TfNSW reference: WST24/00198/001 | SF2024/097119

SSD-41294067 – Copi Mineral Sands Mine – Multiple lots – Anabranh Mail Road, Pine Camp

Attachment 1

Figure 7 – Anabbranch Mail Road and Silver City Highway intersection upgrade (Source: Amendment report, Appendix 1, August 2025)

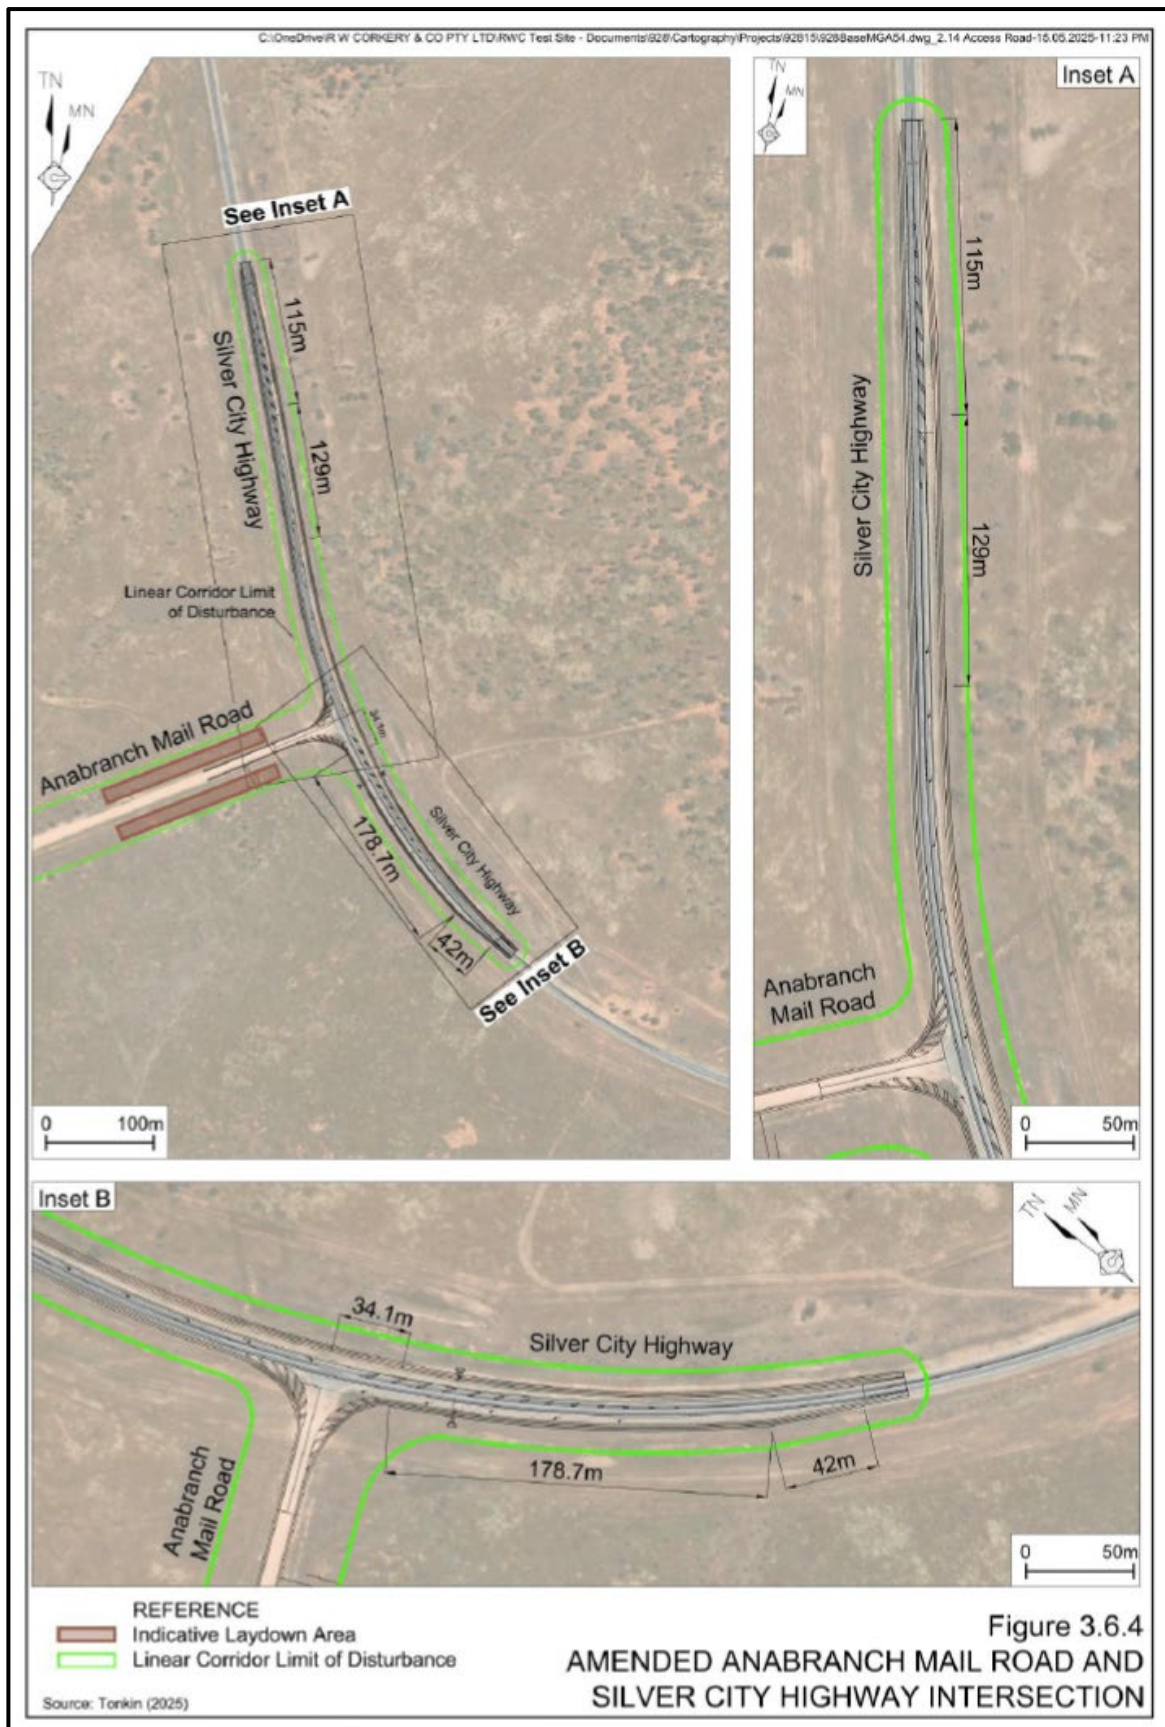
TfNSW has reviewed the documents provided with the application including (inter alia) the proposed haulage route and the BAR/BAL upgrade at the intersection of Silver City Highway / Anabran Road.

While TfNSW acknowledges that the proposed upgrade is based on the anticipated traffic generation volumes and the through traffic plotted on the intersection treatment warrants graph in Section 3.3.6 of *Austroads Guide to Traffic Management Part 6: Intersections, Interchanges and Crossings Management*, TfNSW does not accept that a BAR/BAL is an appropriate intersection treatment to support the turn movements generated by the proposed mine in the subject road environment, being a remote, high-speed rural road with a high proportion of heavy vehicle traffic. Accordingly, the proposed BAR/BAL upgrade is not supported.

1. A strategic road design plan for a Channelised Right-turn (CHR) / Auxiliary Left-turn (AUL) treatment at the intersection of Silver City Highway / Anabran Mail Road, designed in accordance with Austroads Guides, Australian Standards and relevant TfNSW supplements and standards. The design must consider (inter alia):

- a. Design speed,
 - b. Deceleration of the design vehicle,
 - c. Capacity for storage of at least one design vehicle,
 - d. Necessity for lighting at the remote location in accordance with AS1158.3:2020,

- e. Assessment of the access achieves SISD, Minimum Gap Sight Distance, Approach Sight Distance and Safe Stopping Distance in accordance with Part 4A of *Austroads Guide to Road Design* and TfNSW's supplement (TS 02642:1.0),

2. Longitudinal drawings to illustrate the required Safe Intersection Sight Distance (SISD) at the access location. The application should be supplemented with scaled drawings illustrating the SISD in a plan format for the design speed as well as a 2.5sec Rt to account for traffic activity outside daylight hours or in adverse weather conditions.
